From: [Chris Cruse](#)
To: [Zach Torrance-Smith](#); greg@irisheyesgardenseeds.com
Cc: [Jamey Ayling](#); [Bradley Gasawski](#)
Subject: Re: SP-24-00014 MLH - Transmittal of Comments
Date: Friday, December 6, 2024 9:49:36 AM

From: Zach Torrance-Smith <zach.torrancesmith@co.kittitas.wa.us>
Sent: Tuesday, December 3, 2024 10:44 AM
To: greg@irisheyesgardenseeds.com <greg@irisheyesgardenseeds.com>; Chris Cruse <chris@cruseandassoc.com>
Cc: Jamey Ayling <jamey.ayling@co.kittitas.wa.us>; Bradley Gasawski <bradley.gasawski@co.kittitas.wa.us>
Subject: SP-24-00014 MLH - Transmittal of Comments

Please see the attached correspondence regarding your short plat application (SP-24-00014 MLH). A physical copy of the correspondence has been placed in the mail.

**Critical Areas Map**

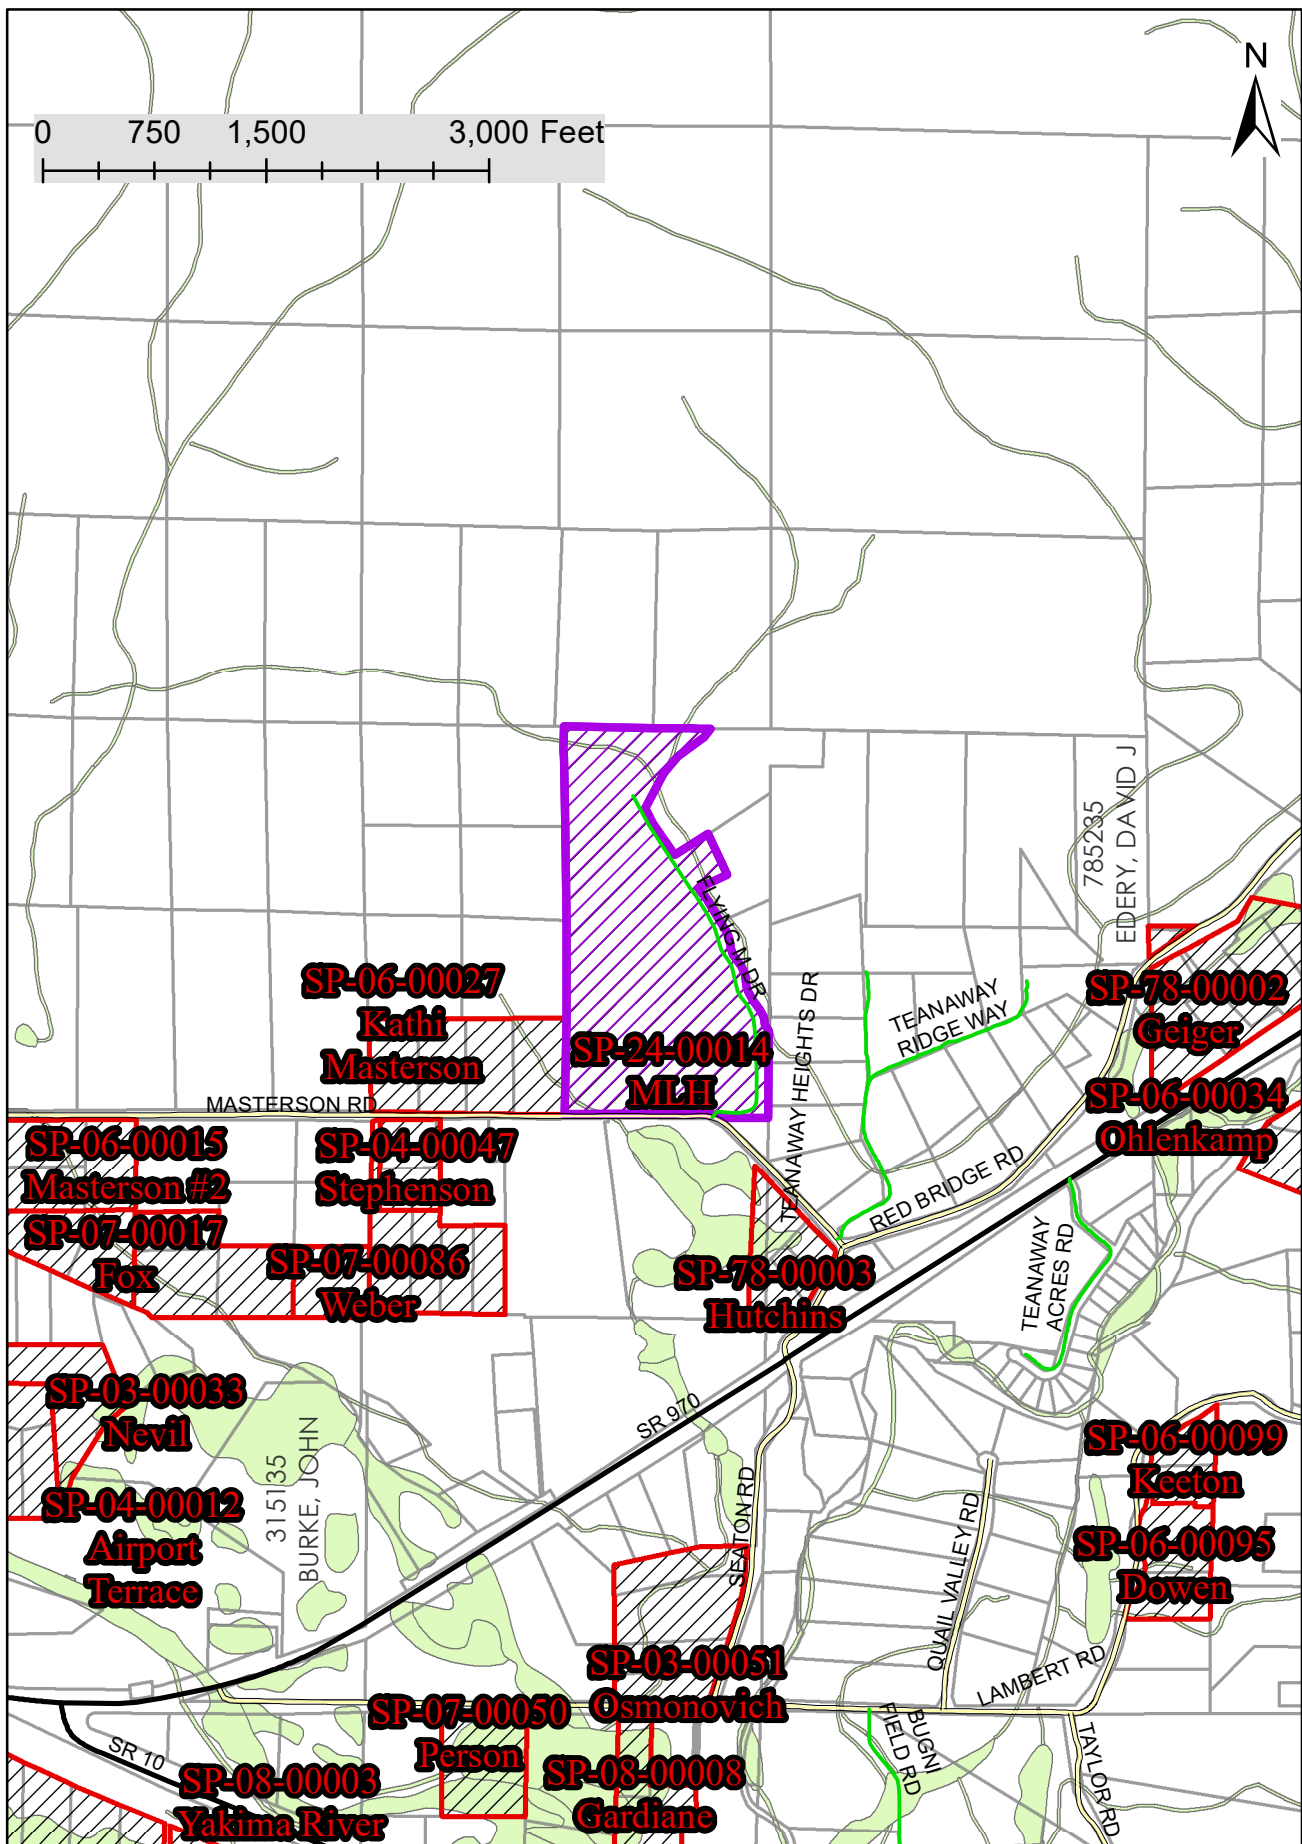
Critical areas - Masterson Ditch no longer exists as it was replaced by an underground irrigation pipeline years ago and has been filled in intentionally and naturally on this property and other properties along the old ditch route east to the Teanaway river. No evidence remains or was observed for the Masterson Ditch or any tributary on this property and a critical area report should not be needed for this application. Again, we are not creating any additional buildable parcels as most of the property is already within a conservation easement. Placing a notice on the plat that further review and permitting may be required for future development should address any concerns.
